Your ref: SSD-48160216  
Our ref: DOC24/736122-1

**Subject: Maison Dieu Solar Farm**

Thank you for your Major Projects Portal request dated 6 September 2024 seeking advice from the Biodiversity, Conservation and Science (BCS) Group of the NSW Department of Climate Change, Energy, the Environment and Water (DCCEEW) on the Maison Dieu Solar Farm Environmental Impact Statement (EIS).

## Attachment 1 - BCS Comments

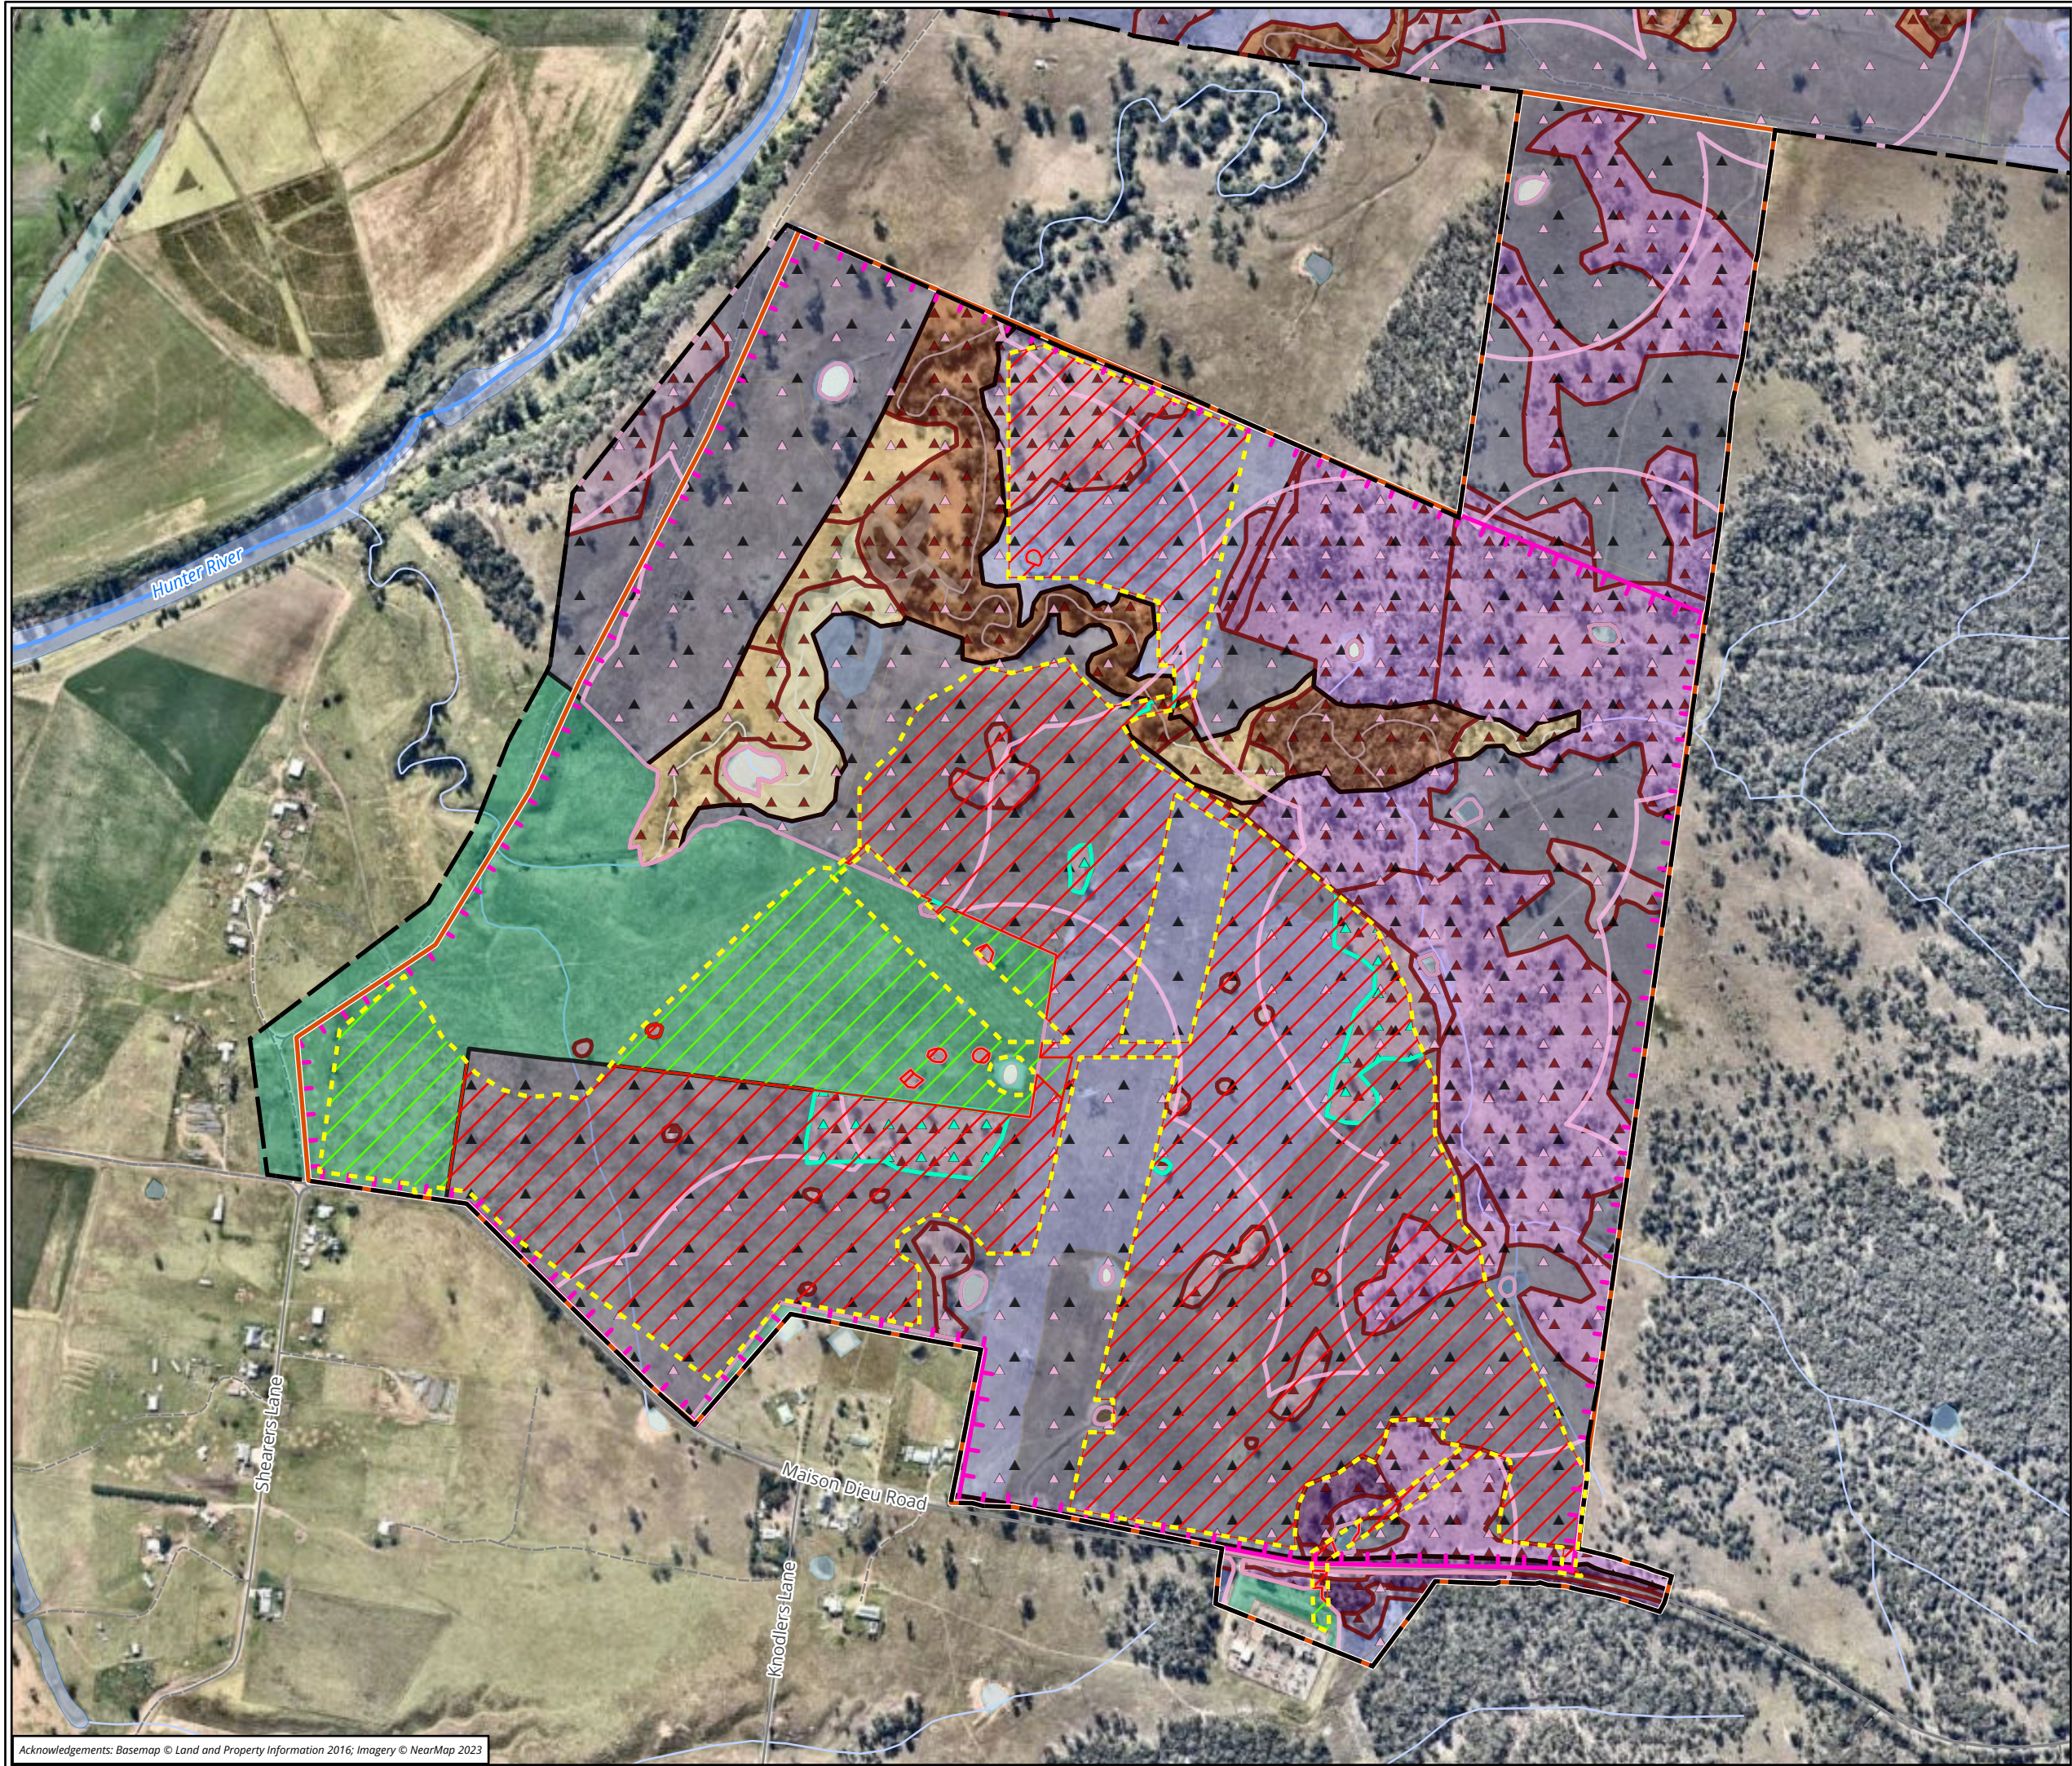
<i>Extent and Timing</i>	Pre-determination
8.	Insufficient avoidance of Striped Legless Lizard habitat	<p>The BDAR states that the project will impact approximately 19.5% of Striped Legless Lizard habitat within the Study Area, equating to approximately 75ha. As stated in S5.1, avoidance of Striped Legless Lizard habitat is difficult as it inhabits degraded DNG areas on site which are the most suitable for development. However there needs to be additional details provided to demonstrate avoidance of habitat for this species, particularly in the south-eastern portion of the site where there is a high concentration of Delmar records.</p> <p><b>Recommended action:</b></p> <p><i>Further avoidance of areas of high quality habitat for the Striped Legless Lizard should be considered in the eastern portion of the project area. This could include extending the disturbance footprint/design further into Cat 1 areas in the south west.</i></p>
